## 1.0 Introduction & Summary

- 1.1 At some point in the late summer or Autumn of 2022, National Highways are expected to submit to the Planning Inspectorate their solution to improve the traffic congestion problems at Arundel.

- 1.2 This solution will be based on the preferred route – the Grey route – a decision that has mystified many as it is the preferred route of only one group, National Highways.

Arundel A27 Bypass Journey Times Savings: The Truth

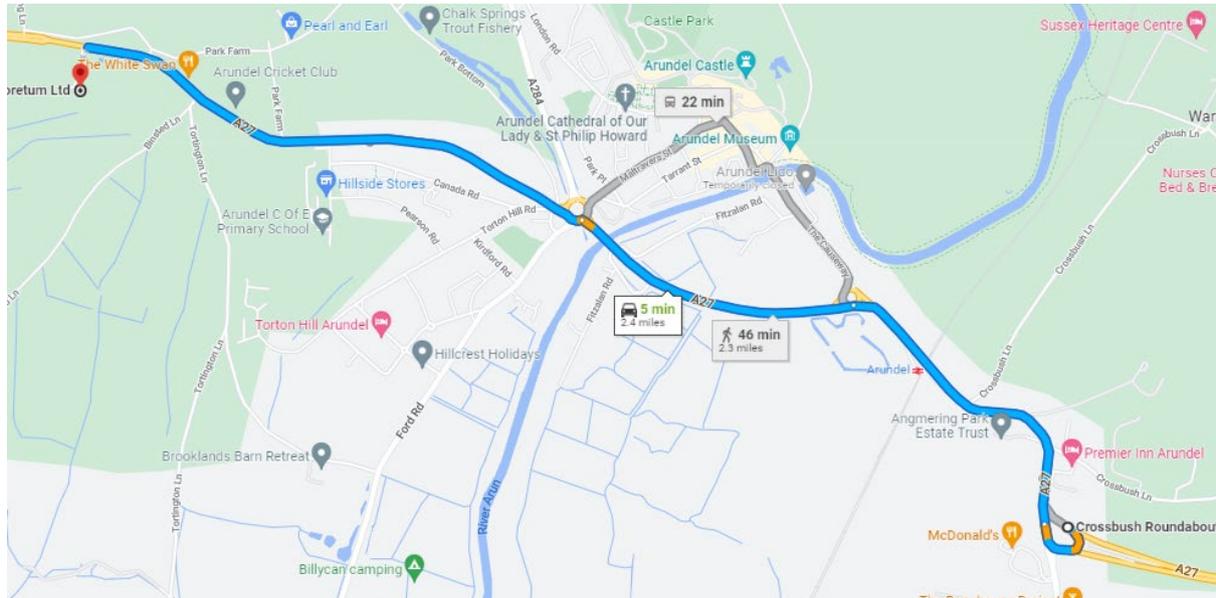
- 6.1 Congestion occurs leading up to and on the 2.5 miles of single carriageway between the dual-carriageways to the east and west of Arundel as shown in the image below. Not on the 2.5 miles dual-carriageway between Arundel and Fontwell.

6.2 Traffic congestion in Arundel (because of the single carriageway and junctions) extends travel times mainly at peak hours (the following are National Highways figures.)

- Eastward (am) – journey times extended by 35 seconds
- Westbound (am) – journey times extended by 1 minute
- Eastbound (pm) – journey times extended by 8 minutes
- Westbound (pm) – journey times extended by 1 minute

6.3 The total journey time over 5 miles without congestion takes on average 10 minutes.
